Our Ref: ID 3264
Your Ref: SSD-67173718

State Significant Development Application for New Eileen O'Connor School

Thank you for the opportunity to provide comment on the State Significant Development Application (SSDA) for the proposed new Eileen O'Connor School at 84 Gavenlock Road, Mardi, the existing St Peters Catholic College site. It is understood that the proposal is for the construction and operation of a new school that will provide education and allied health facilities,¹ with **71 full-time equivalent (FTE) staff** and **200 students, children with special needs from kindergarten to Year 12**. It includes:²

FIGURE 4

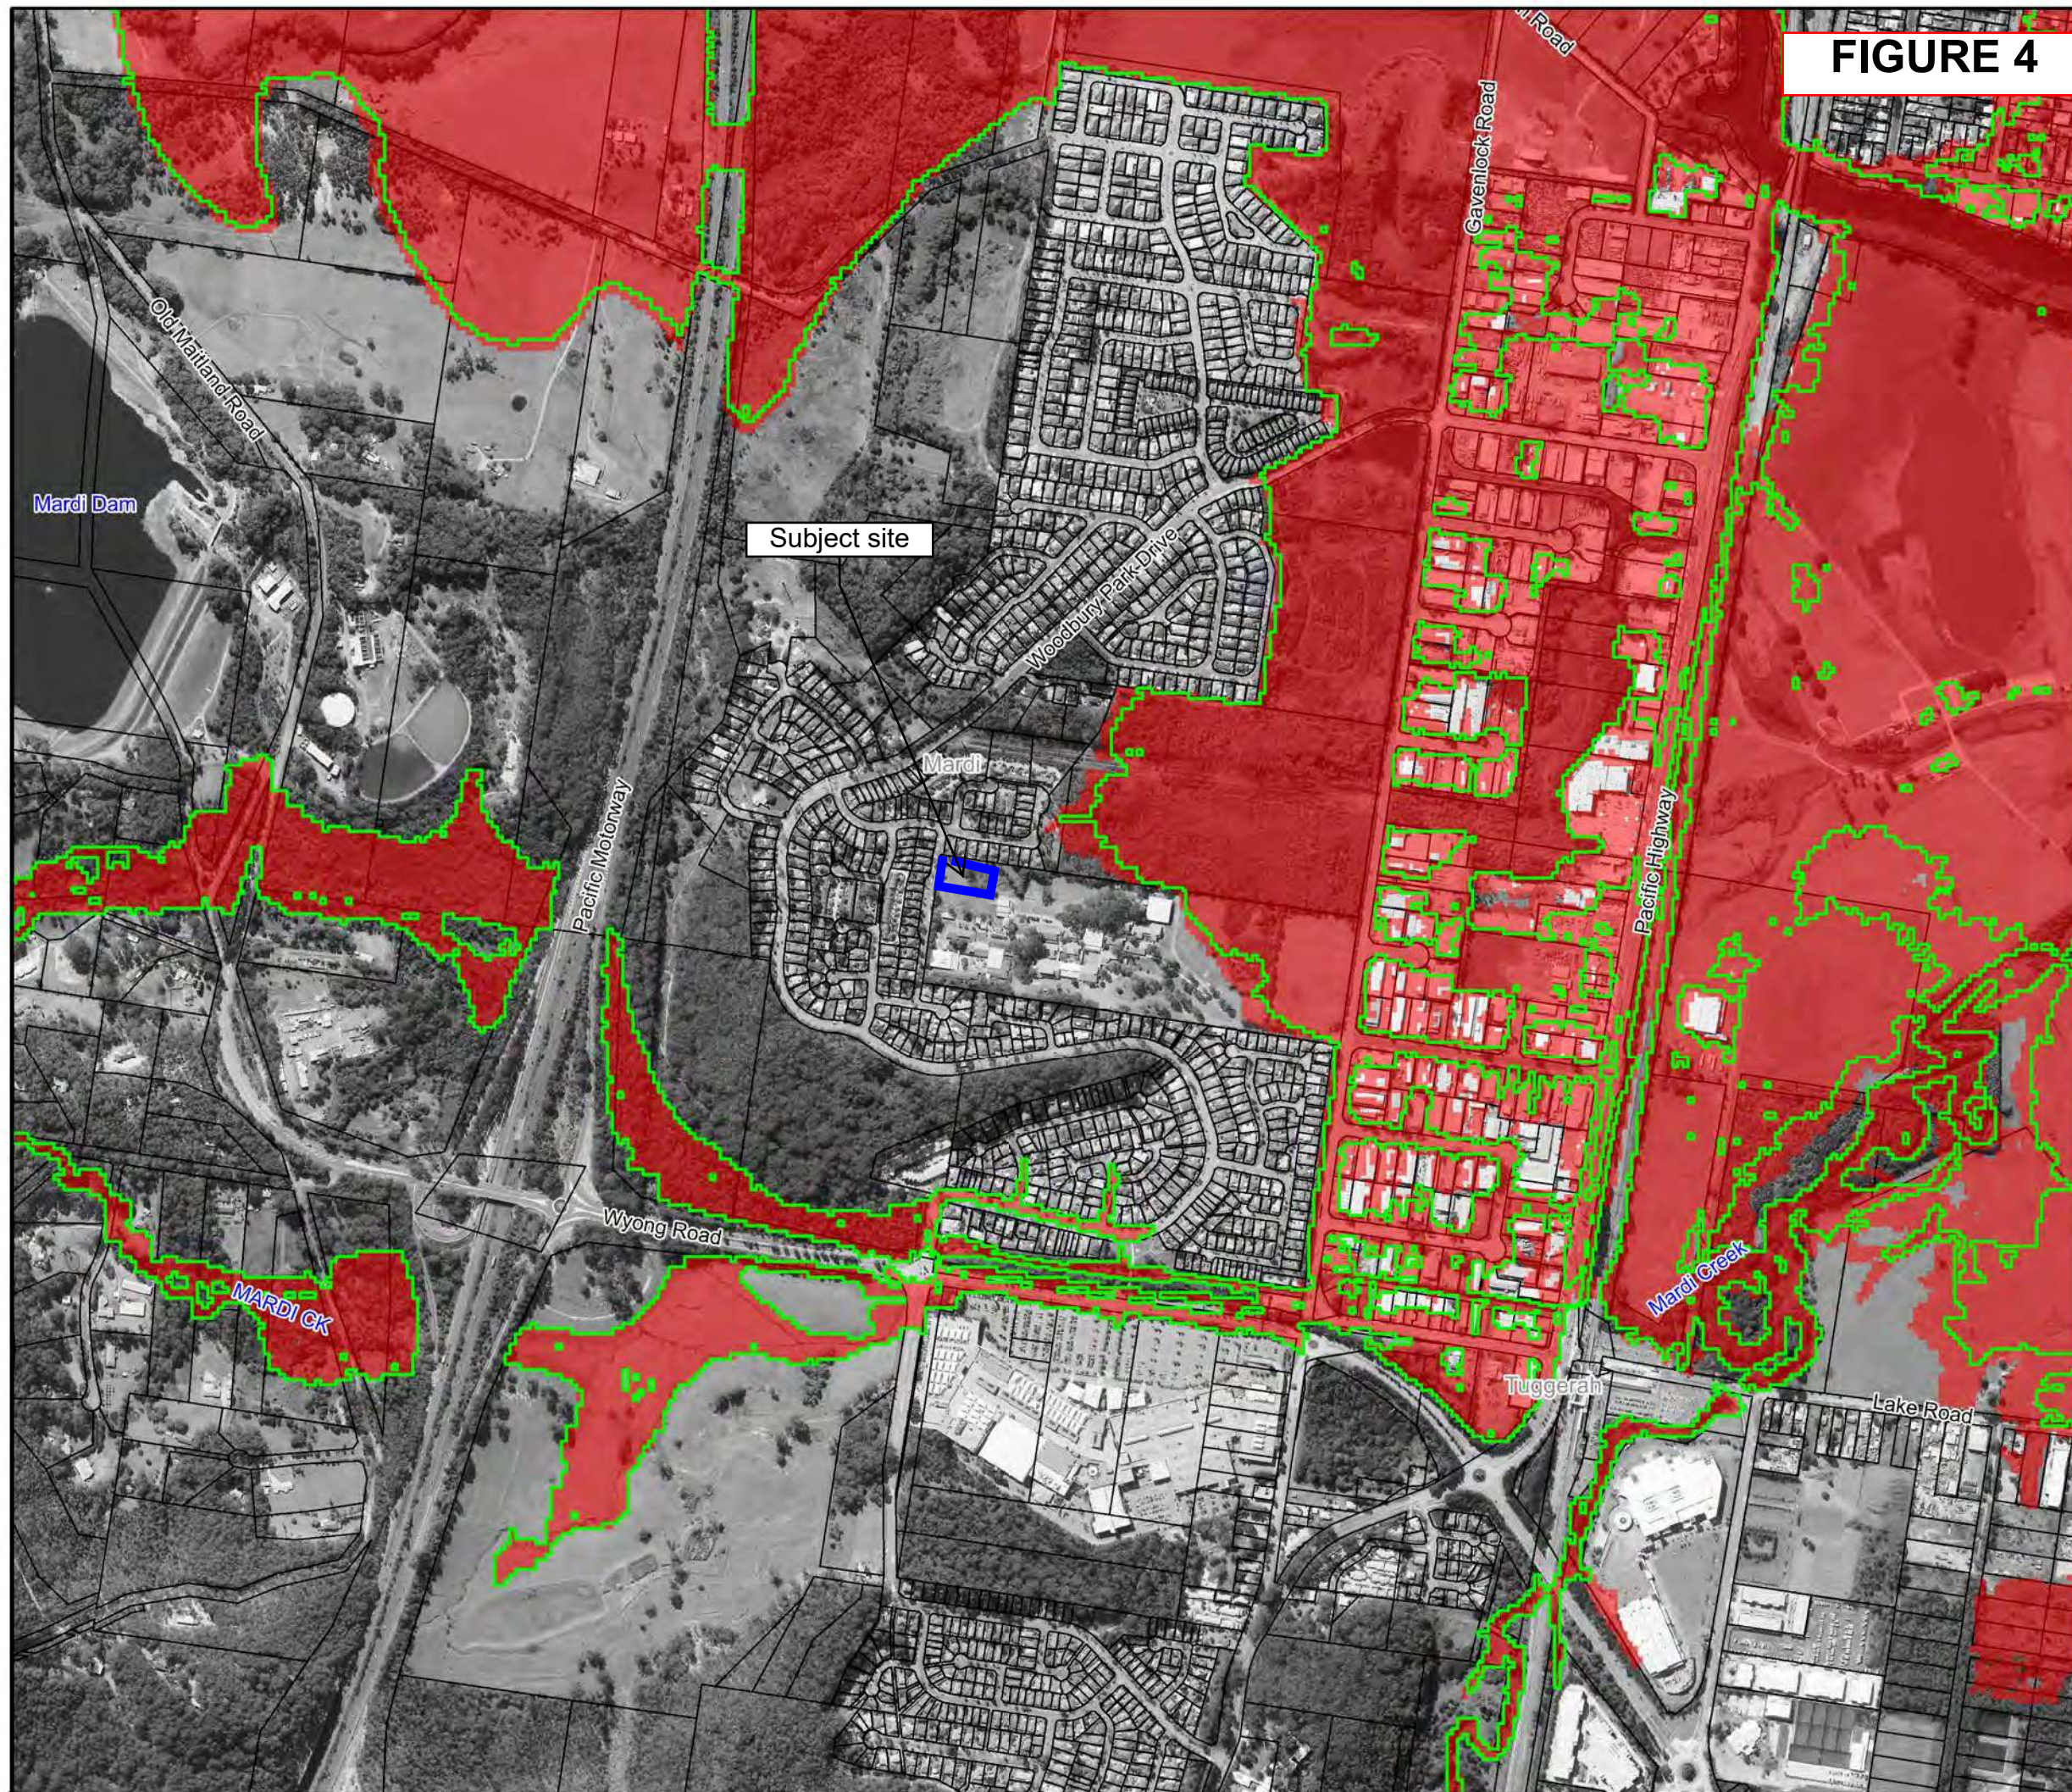
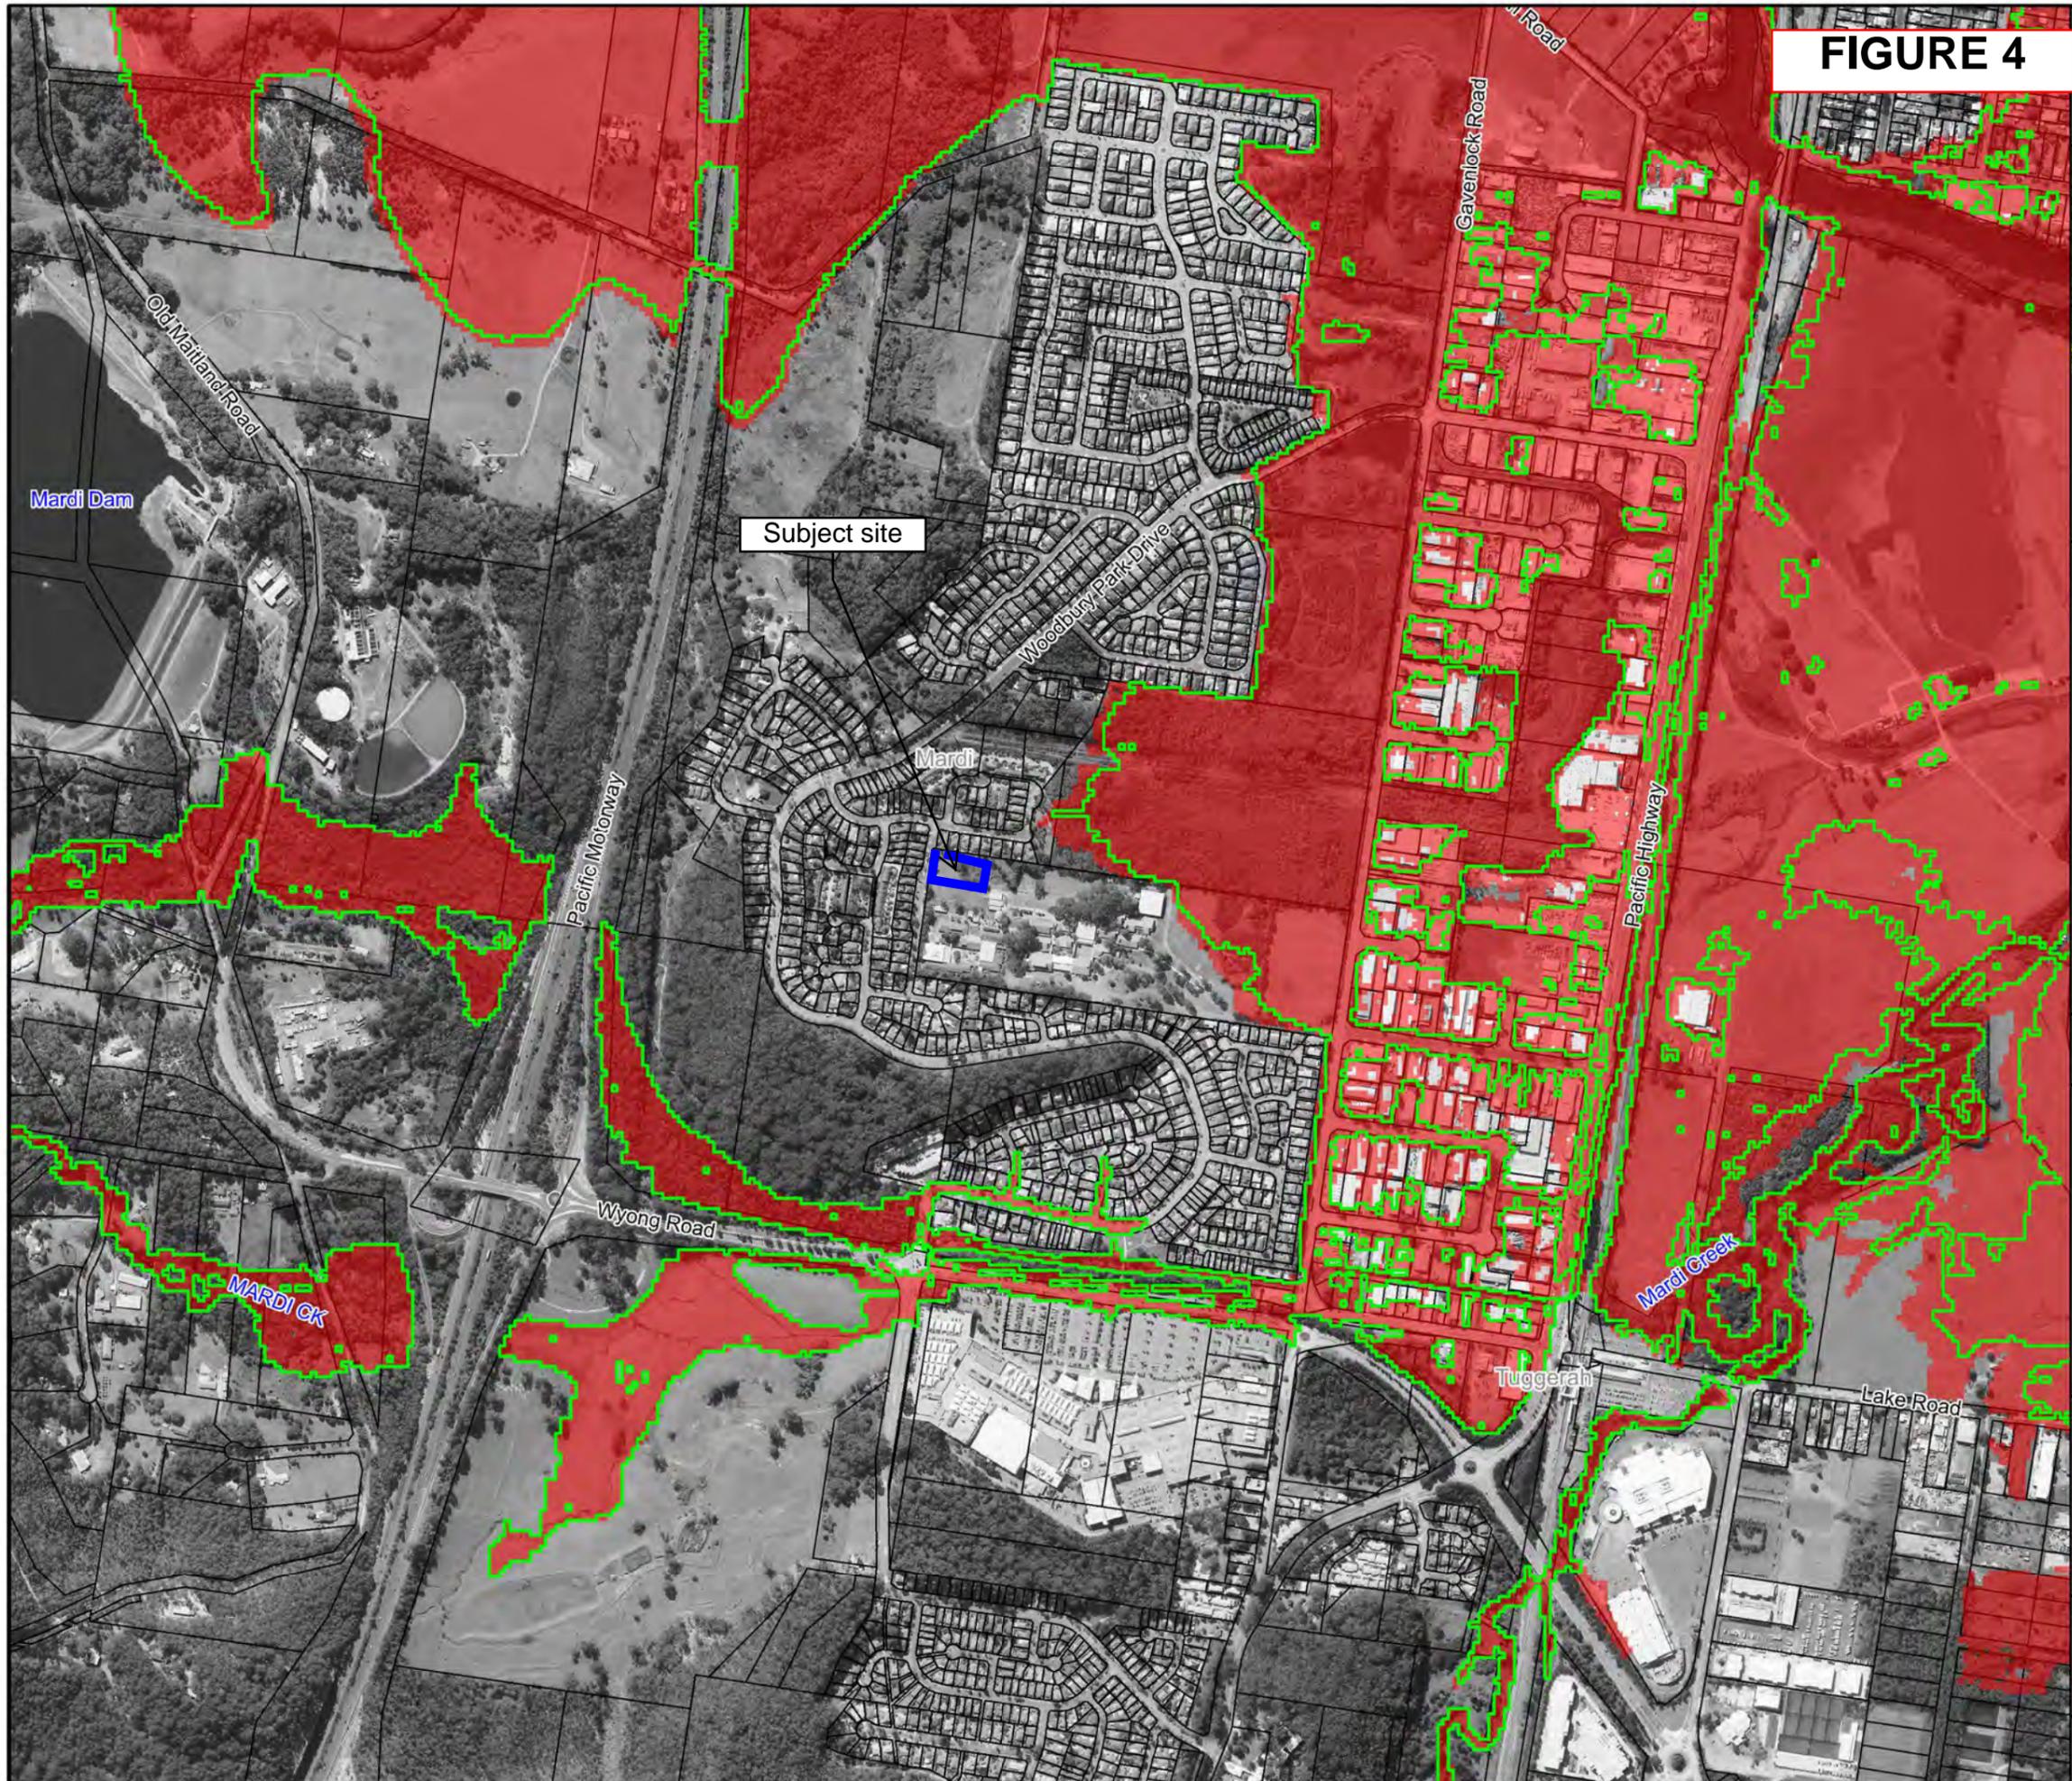
Note that the broader St Peters Catholic College site becomes impacted by flooding and access gets cut as frequently as 20% Annual Exceedance Probability (AEP) mainstream flooding events,³ with the eastern part of the site inundated by flood depths of up to 3 metres in a Probable Maximum Flood (PMF) event.⁴ The proposed *new* Eileen O'Connor School site is in the northwestern area of the broader site⁵ and appears to be outside the mainstream PMF flooding extent, with some minor flooding along part of the northern boundary.⁶ While immediate site access is via Keefers Glen which appears to not be impacted by mainstream flooding, the broader Mardi urban area loses access when Woodbury Park Drive is cut, which can last between **21 - 38.5 hours**.⁷ The identified flood risk at the *site is isolation for long periods* during flood events when roads are cut by high hazard floodwater,^{8,9} with the site being a **high flood island**. NSW SES has responded to multiple flood rescue requests for people trapped in their vehicles by floodwater in this area, including at the southern and northern ends of Woodbury Park Drive i.e. at its intersection with Wyong Road (south of the site), and along Johnson Road (north of the site), as well as on Gavenlock Road, Mildon Road and the Pacific Highway (east of the site).

The broader St Peters Catholic College (84 Gavenlock Rd, Tuggerah) site becomes impacted by flooding and access gets cut as frequently as 20% Annual Exceedance Probability (AEP) mainstream flooding events,³⁴ with the eastern part of the site inundated by flood depths of up to 3 metres in a PMF event.³⁵ However, we note that the proposed new Eileen O'Connor School site is in the northwestern area of the broader site³⁶ and has frontage to Keefers Glen to the west for both vehicular and pedestrian access/egress.³⁷ According to the modelling, it appears that both the new school site and Keefers Glen may be outside the mainstream PMF flooding extent, with just some minor flooding along part of the northern boundary.³⁸ However, we further note that the study focused on assessing mainstream flooding from
